COLORADO GEOLOGICAL SURVEY AT THE COLORADO SCHOOL OF MINES

May, 14, 2018

Ms. Kari Parsons  
El Paso County Community Development  
2880 International Circle, Suite 110  
Colorado Springs, CO 80910  
Re: Windingwalk Filings #1 and #2, PUD and Preliminary Plan, CGS EP-18-0037\_2

UTILITIES & GRADING PLAN

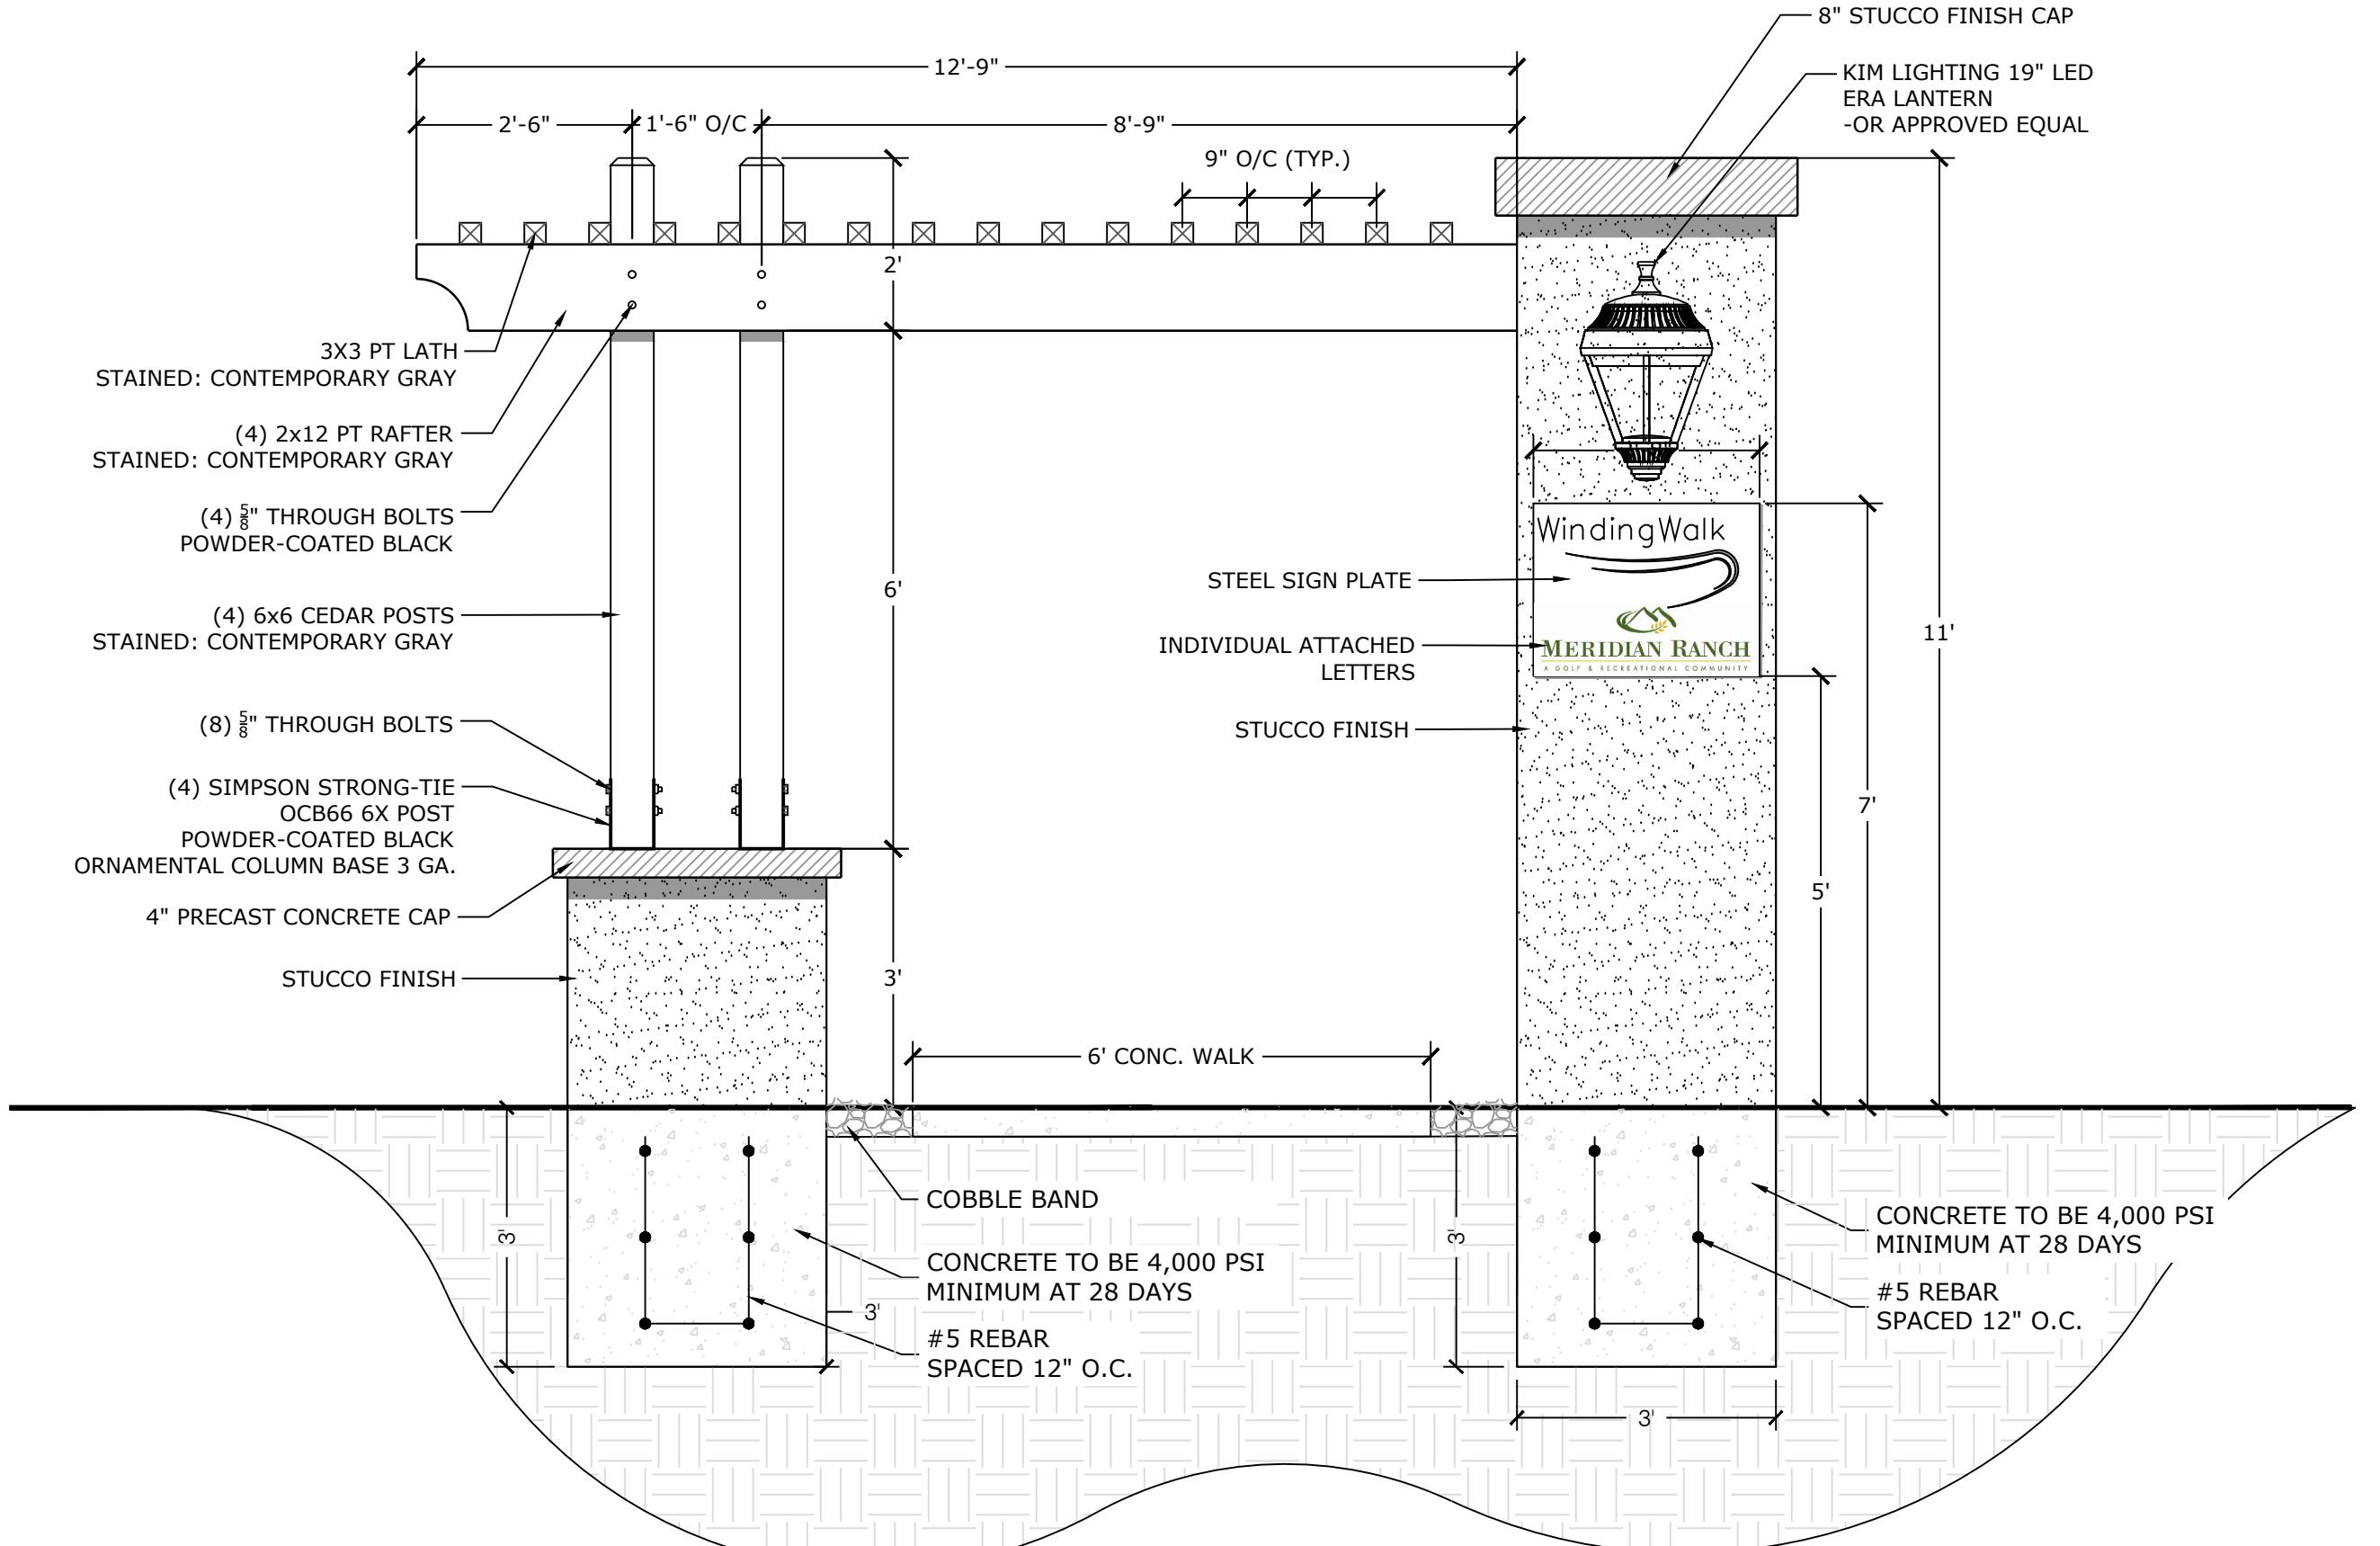
The Entech report states that construction of an area-wide underdrain system should be considered for long-term groundwater mitigation. Though a preliminary utility plan was provided, I was unable to find a legend but assume the plan only shows main lines and stubouts for water and sewer. A properly designed, constructed, and maintained area-wide underdrain system will also improve the long-term performance of homes, sanitary sewer, roads and other utilities.

The system would need to be installed as part of the public improvements and provisions for service line connection stubouts to each lot should be provided. In addition, all segments of the subsurface groundwater collection pipe and the gravel

bedding should have positive drainage. This includes segments dammed by manhole bases. Cleanouts will need to be placed at bends or junctions in the main collection lines and along the main collection lines. The cleanouts will be of sufficient size to allow for proper maintenance.

TEST BORING LOCATION PLAN
 WINDINGWALK FILINGS 1 AND 2, AND
 STONEBRIDGE THE ENCLAVE FILINGS 4 AND 5
 EL PASO COUNTY, CO.
 FOR: TECH CONTRACTORS

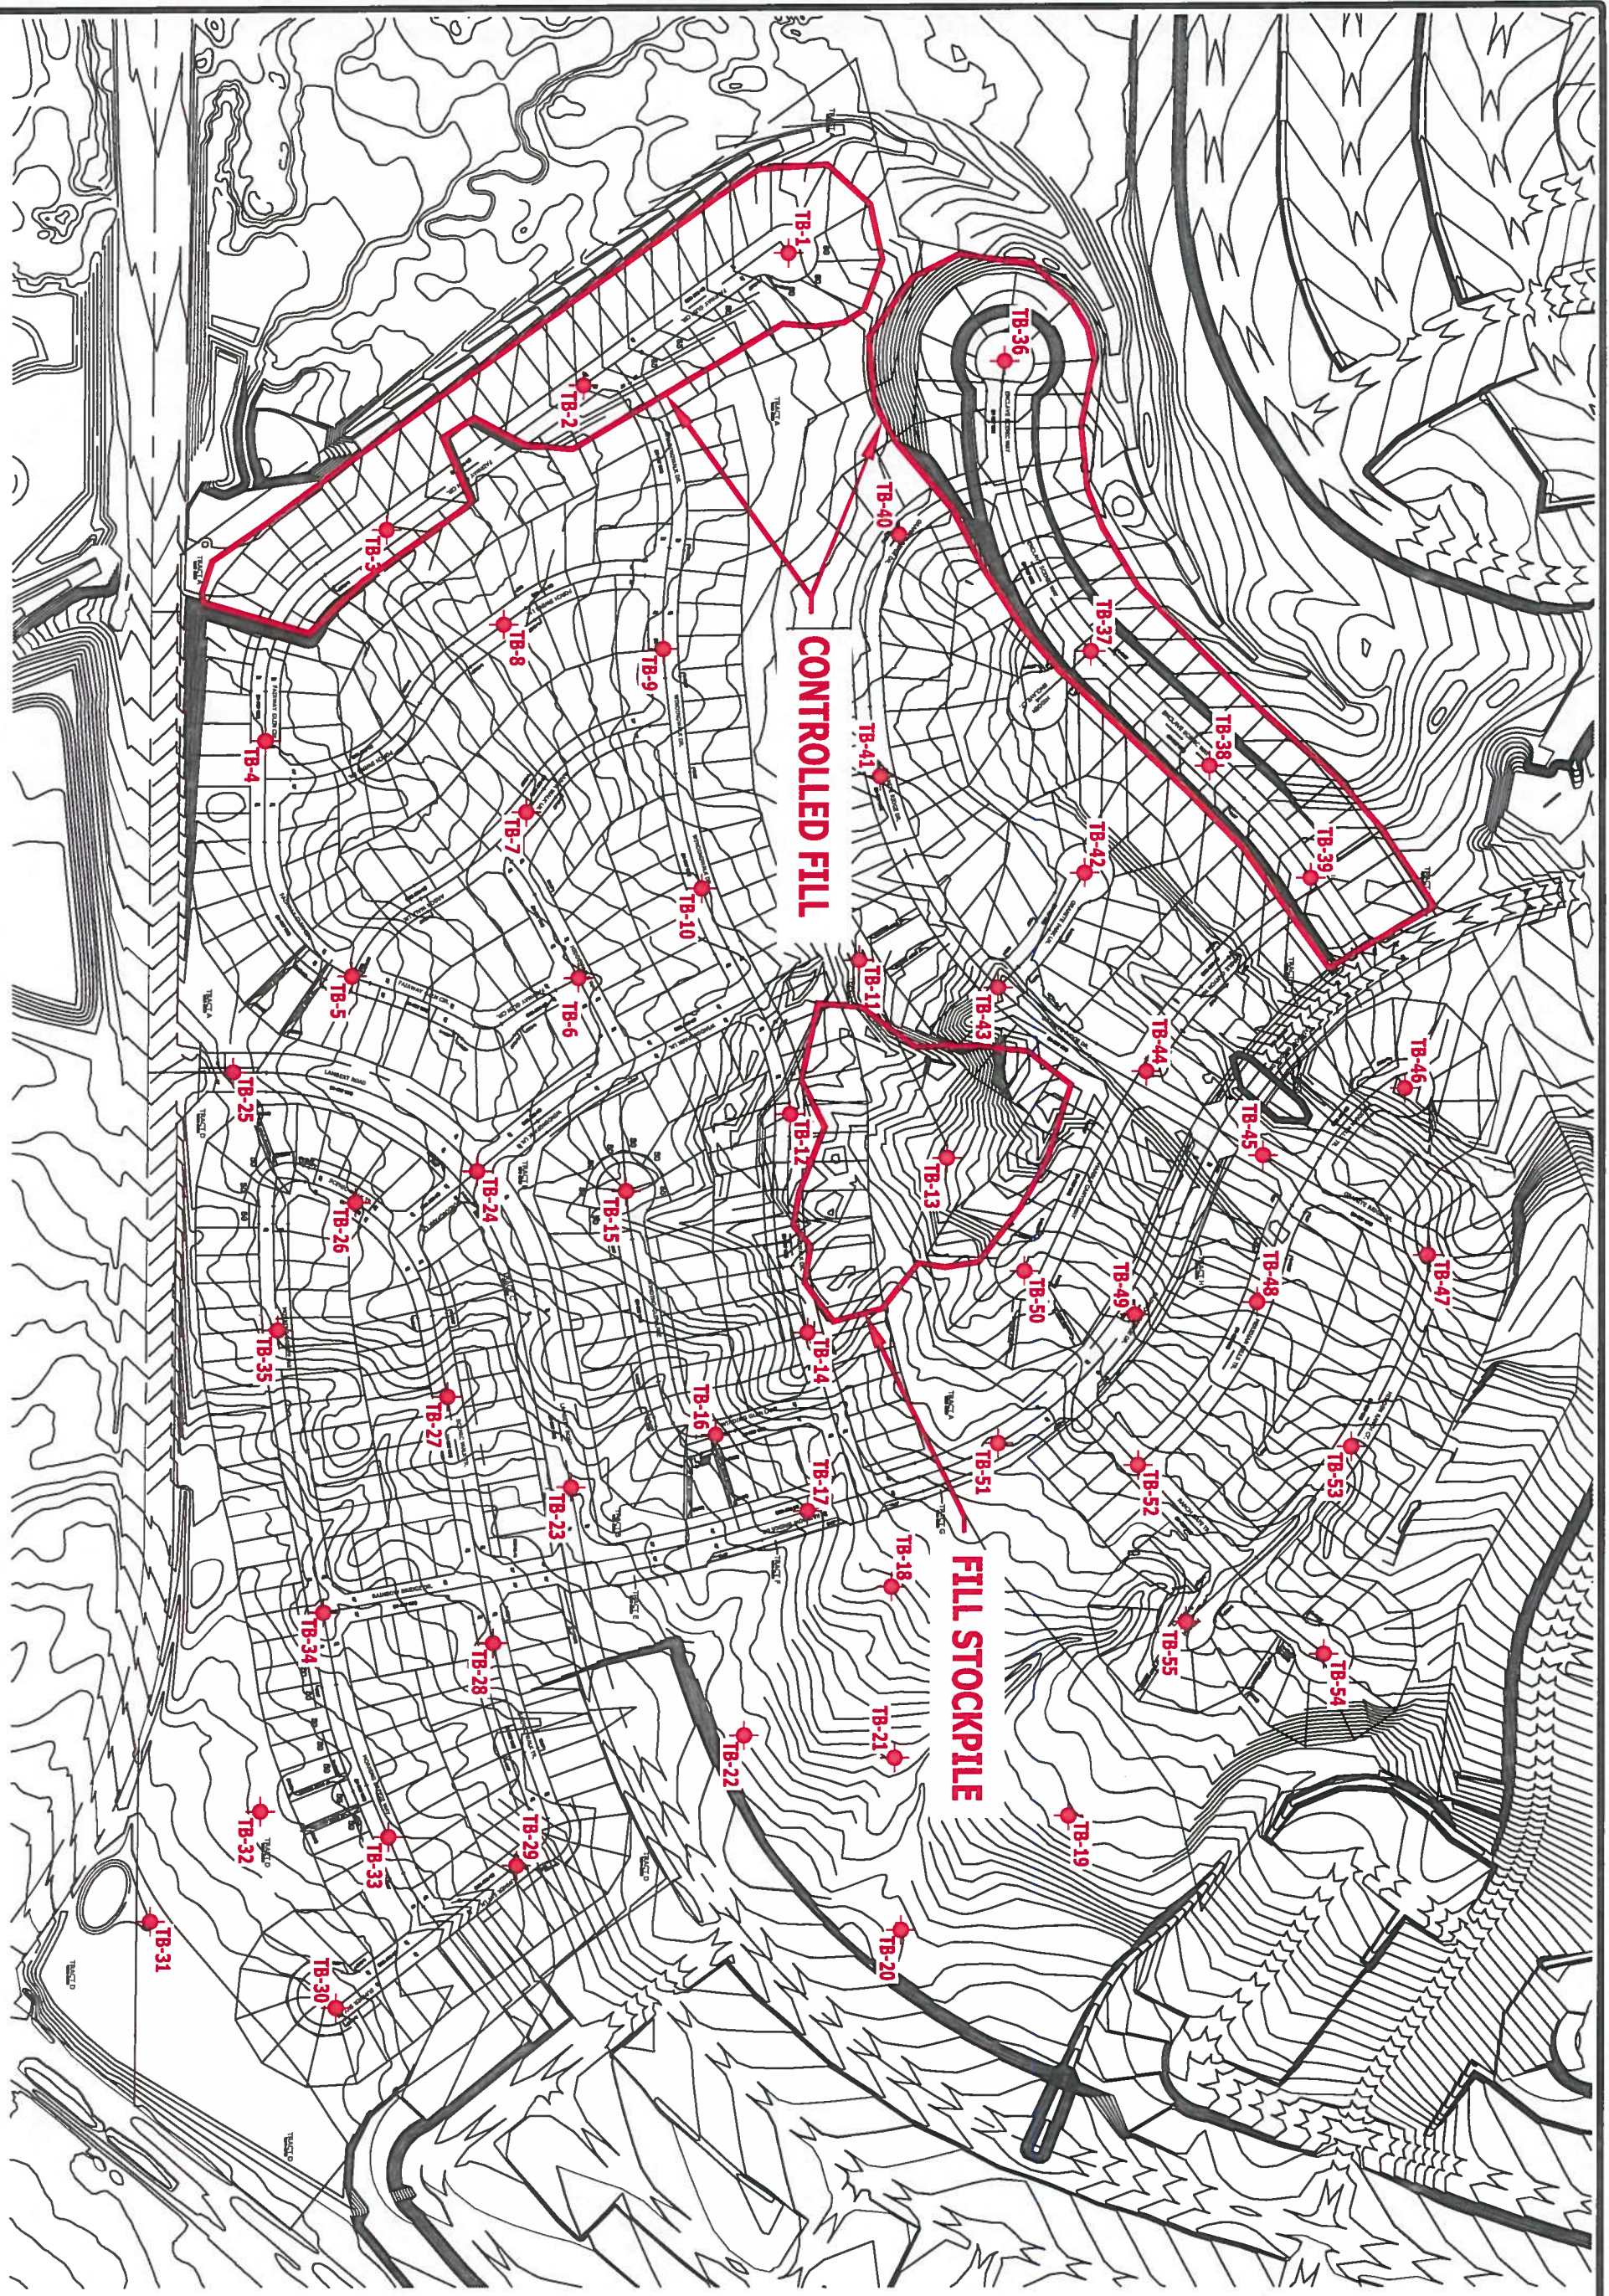
As noted in the previous CGS letter and in the geotechnical report, the southern, western, and northern sections of Filing 1 (Lots 24-55; 152-159; 162-163; and Fairway Glen Circle) are underlain by fill. Per the Entech report, the fill is reported to be properly placed and compacted. However, the report also states that Entech has not been given the required documentation to show the fill was properly placed and compacted as engineered fill.

Improperly placed fill may be subject to excessive settlement, and instability, during construction of foundations, roads, and utilities. Without such documentation, it would be prudent for the county to require the fill to be removed and replaced as engineered fill. This will need to be done as part of the public improvements.

The sand layers are generally located in the western section of Filing 1 near or below areas where fill has been placed (Lots 24-55; 152-159; 162-163; and Fairway Glen Circle). Since it's likely that the fill will need to be removed and replaced as engineered fill, CGS also recommends that any unconsolidated sand below the fill be mitigated to reduce collapse potential.

As previously noted by CGS and by Entech, the site is underlain by shallow groundwater. Almost all of Filing 1 and the western section of Filing 2 show groundwater levels within five feet of foundation levels. The geotechnical report does not contain any sustained groundwater monitoring. It appears that water levels were measured shortly after drilling. The dates of monitoring are not included in the report. It is not known if any measurements were taken when water levels are seasonally high.

In addition, comparing groundwater levels with cut/fill estimates provided by Entech; it appears that some proposed cuts are within five feet of groundwater levels. During periods of seasonally high groundwater levels, groundwater may flow from utility excavations potentially impacting slope stability. If grading plans change, the county may wish to ensure that no permanent cuts are made in areas with shallow groundwater without adequate mitigation.
